The Chimes, Uxbridge

External signage planning feedback

Feb 2025

High Street entrance A - high level glazed bricks

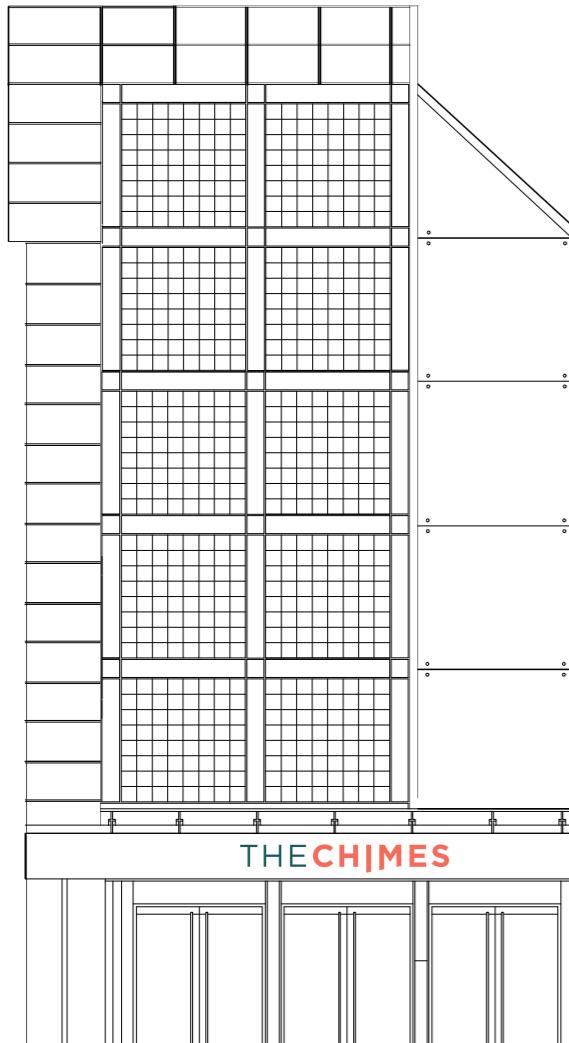
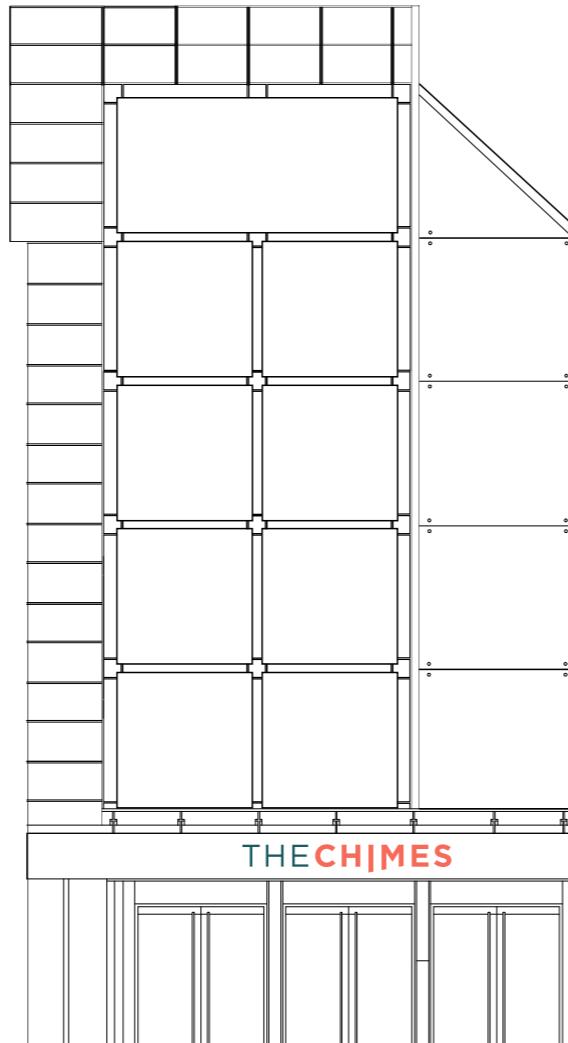
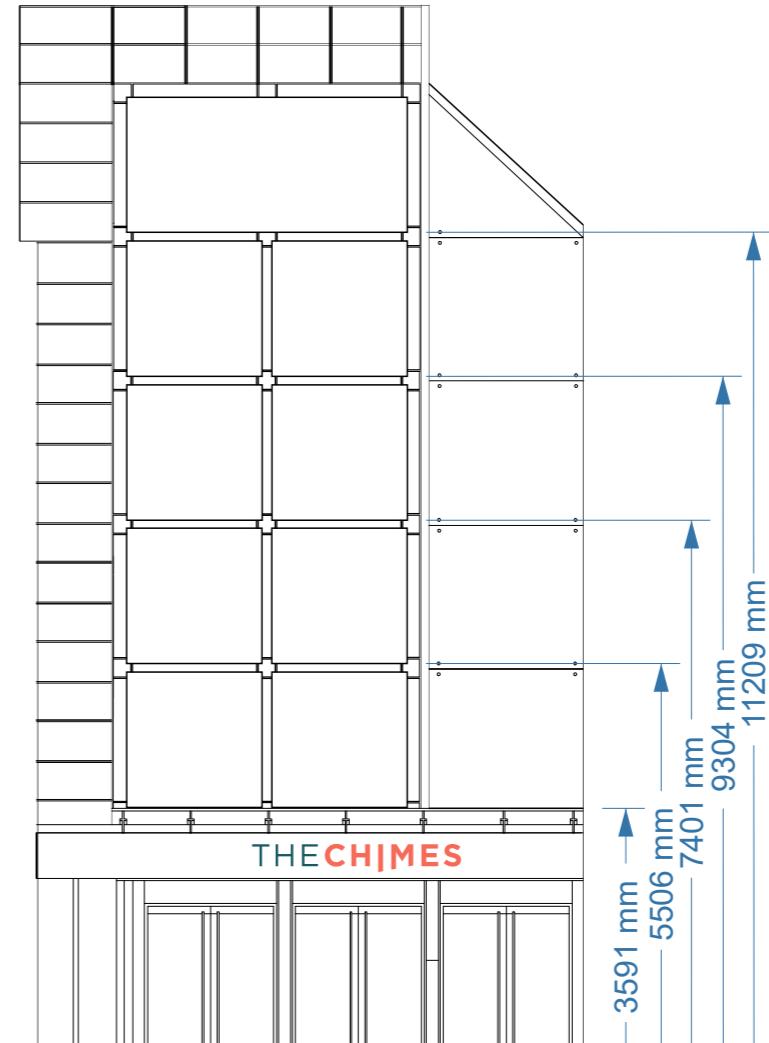
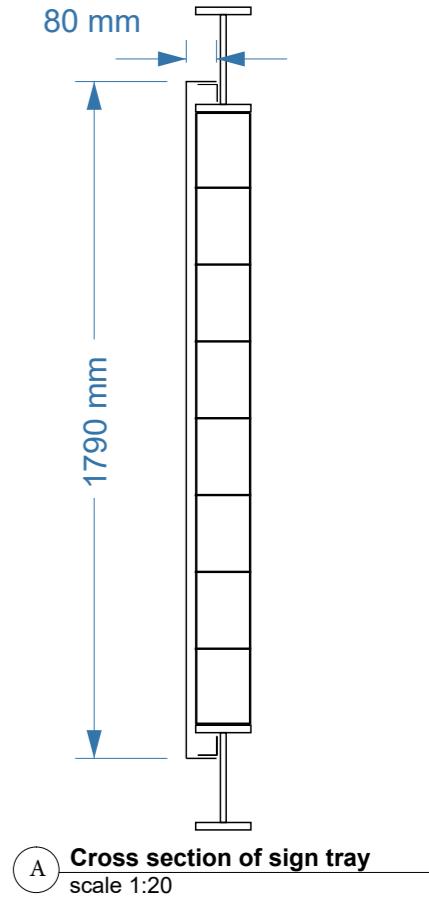
The proposed signage is excessive, visually dominant, and obstructs natural light through the existing glazed bricks, diminishing the public realm both inside and outside the Chimes. The glazed brick contributes to a more seamless transition / visual connection between the interior and exterior, an important aspect of the building's original design and its relationship with the High Street.

We object to the number and arrangement of panels but may be open to reviewing a reduced scheme that better balances permeability and elevational design. For example, limiting advertisement panels to four squares - likely preferably the lower four - to maintain some natural light. We are also open to reviewing alternative arrangements, such as perhaps stacking panels vertically on the left-hand side, exploring a chequered pattern (albeit may be too visually disruptive) or other options with reduced amount of panel boarding. The top horizontal glazing should remain unobstructed. If a horizontal element is desired (e.g. "Come on in"), it may be more appropriate at the horizontal fascia element above the entrance.

In all cases, we recommend that each advertisement panel be set within the existing structural elements rather than being mounted directly onto the surface, ensuring a visual gap around it. In addition to the visual gap, we also recommend that a surround frame is introduced within each panel to create a more cohesive appearance, respecting the original building.

- The current glass bricks have a solid wall behind them, so do not allow any light into the centre. Images to the right show the solid wall that blocks in this area with the bricks themselves sitting behind internal solid walls within the retail units. The glazing to the left (highlighted in red on the images to the right overleaf) as you look out lets all light into the centre and will remain uncovered. The proposal will therefore have no impact on natural light entering the building.

- The current proposal is set within the existing structural elements rather than being mounted directly onto the surface of the glass. The proposal has the signage trays applied in a 'sleeve' around each single section of steel frame that holds the glass bricks. The elevations drawing shows that these sleeves affix to the steel structure returns as close as possible, leaving the natural gap that already exists between the glass brick panels. This is possibly not clear from the visual because it is not face on, so we have adjusted this to emphasise the gap that will be there.

- As no natural light is blocked, it is proposed to retain the current panelling but reduce the size of the retailer logos to be less visually dominant. Ensure that new sign trays are as close as possible to the existing steelwork, retaining the visual steel gap between the current glass brick panels.

High Street entrance B - above doors

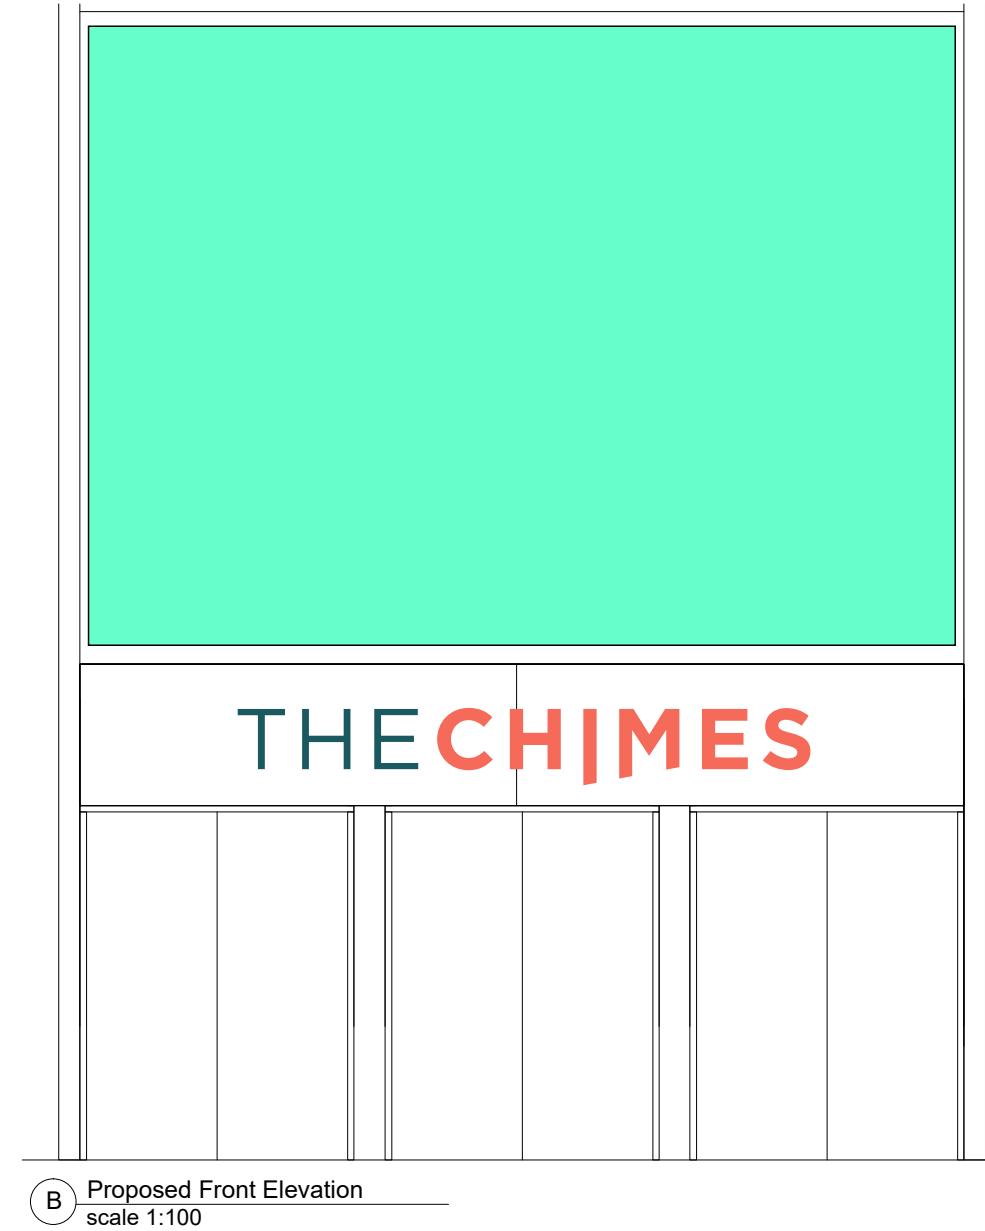
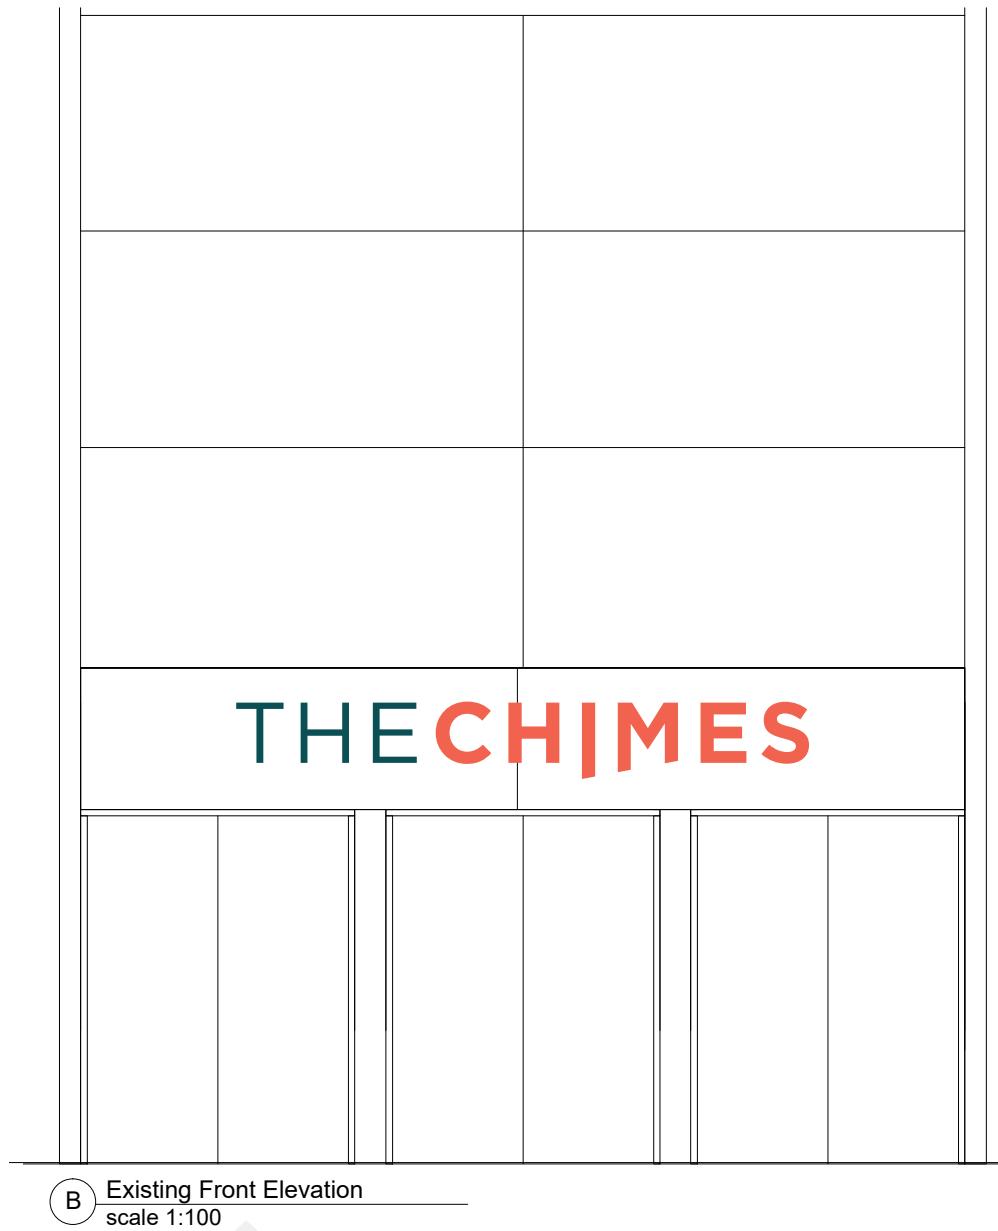
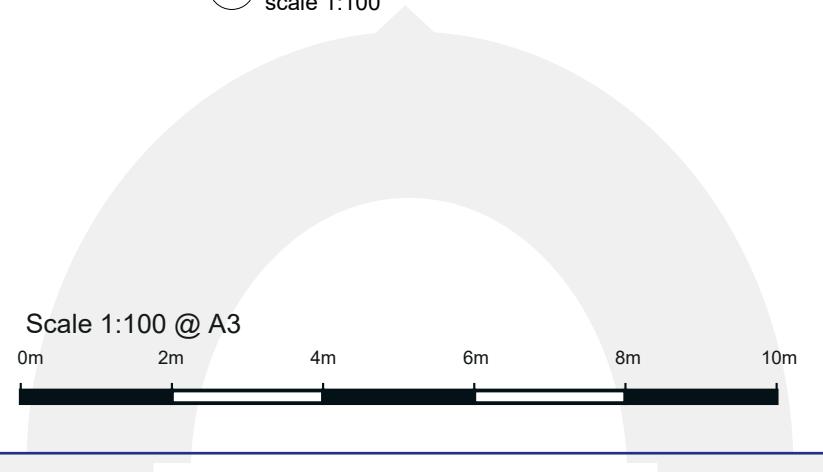
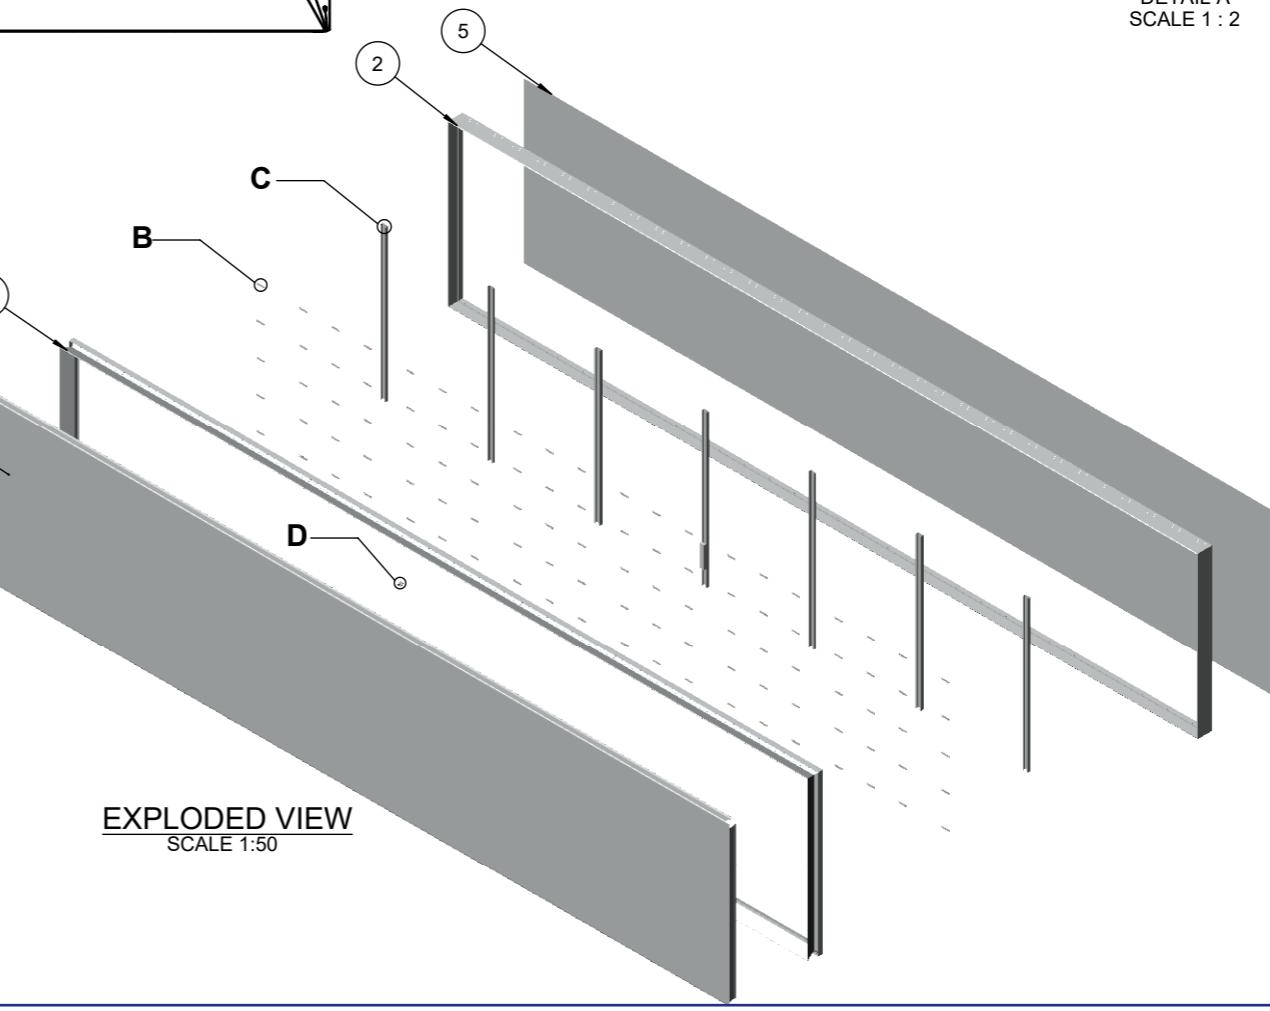
The proposed signage is very large and currently appears "stuck on" and poorly integrates with the building. Similar to Entrance A, introducing a surround frame could help better integrate it with the existing architecture. Introducing individual signs for the brands may be an option should they be removed from the shopping centre in future.

- The new sign has specifically been specified as a signbox which has an outer box frame, as shown on the submitted Flex Box spec sheet. This will ensure it does not look 'stuck on' in the way the existing vinyl signage does, removing the need for the section breaks on the existing.

- Keep the current design as a single signbox but reduce the retailer logo sizes to be less prominent.

Market Square entrance C - high level glazing - NEW

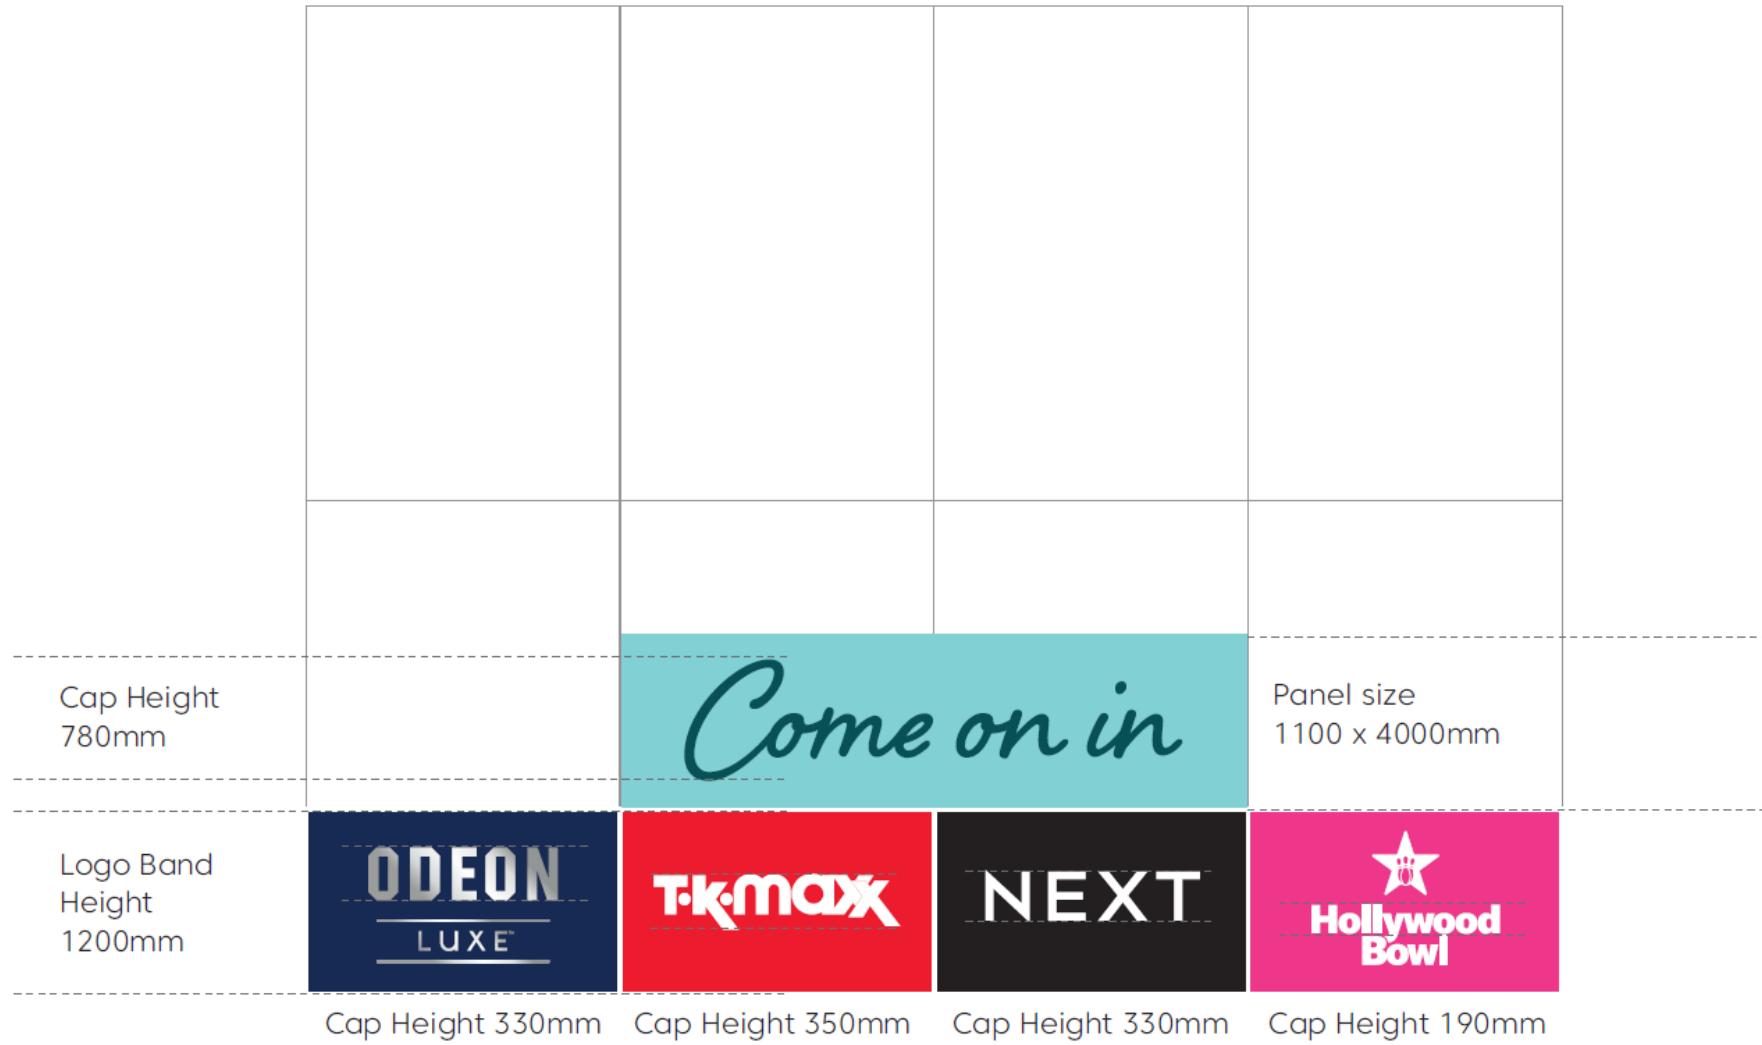
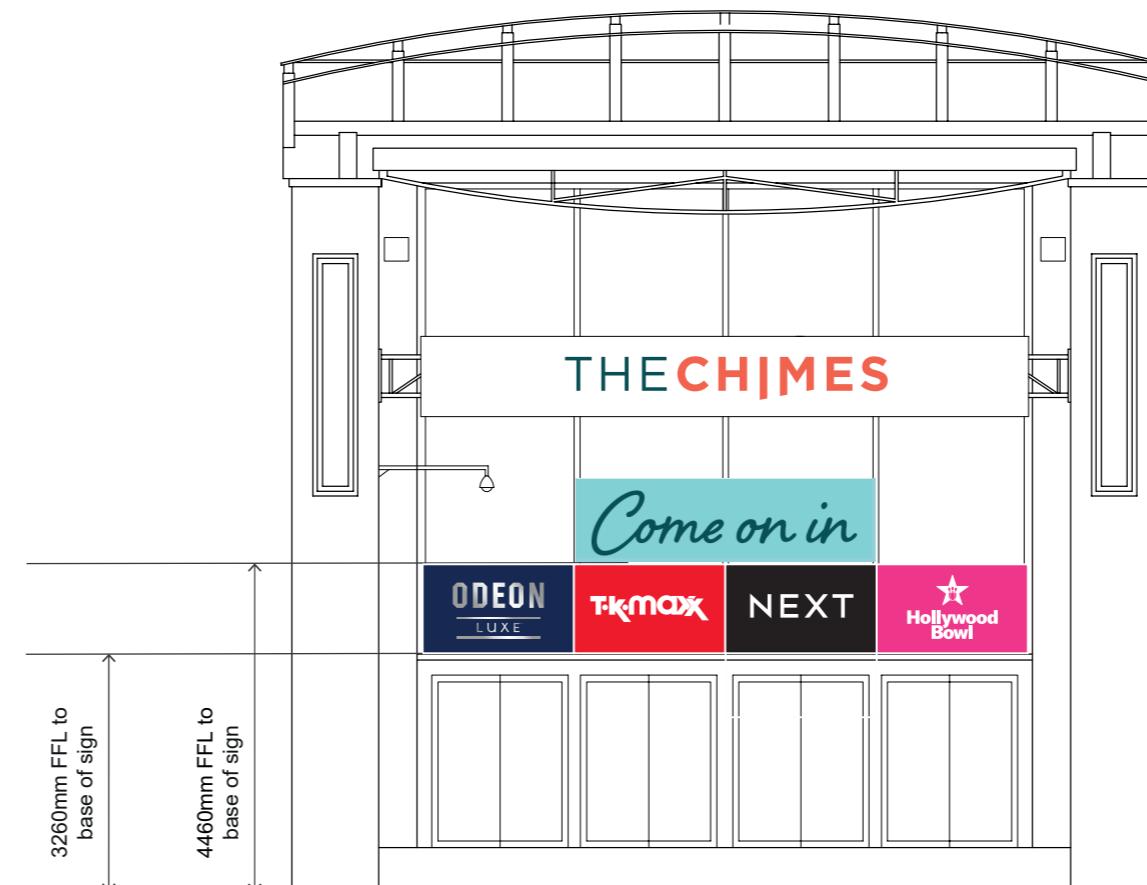
Given its central and sensitive location - being the key piazza in Uxbridge town centre and within the conservation area - we strongly object to the proposed signage in this location. The excessive coverage obstructs important visual links between the outdoor public realm, the High Street, and the internal public realm within The Chimes. It also significantly reduces natural daylight entering the main entrance hall, which in turn diminishes the quality of the public realm both inside and out. In this location, we may be open to a more restrained signage approach that respects the visual permeability and daylight qualities of the entrance. Any signage should:

- *Be minimally intrusive, ensuring clear views in and out.*
- *Maintain a sense of openness, reinforcing the connection between the street and the interior.*
- *Avoid blocking upper-level glazing, preserving daylight penetration.*
- *Be well-integrated within the architectural composition rather than appearing as an afterthought.*
- *Align with the rationalisation principles applied to other entrances, ensuring consistency.*

A more subtle, carefully designed solution - such as signage positioned within existing framework elements or restrained use of transparent/semi-transparent materials - could be explored to maintain the integrity of this key entrance while accommodating branding needs. Details/samples of materials would be beneficial.

- The base section (Come on in) covers the internal floorplate so is not obstructing visual links or daylight but is hiding the unsightly floor joists. This area already has graphic content in place.
- The use of semi - transparent materials (contravision) was discounted as this would look unsightly from the inside (It cannot be printed double sided).
- The current location was designed to only cover the lower central section of the frontage, allowing light in at both the sides and the top.
- It is noted that the current external The Chimes illuminated sign which is situated on the outer pillars obscures part of the sightline out the centre from the inside.

- Adjust the design to reduce the coverage, size and height of the current retailer logos and move these up to create a pillarbox window, retaining clear glazing above and below for visual links between the internal and outdoor public realm. When viewed internally, the logo signs will sit in line with the existing external 'The Chimes' illuminated sign so would not have significant impact on light or visibility.
- The top of the logo signs will be aligned with the framing of the glazing to integrate with the building architecture.
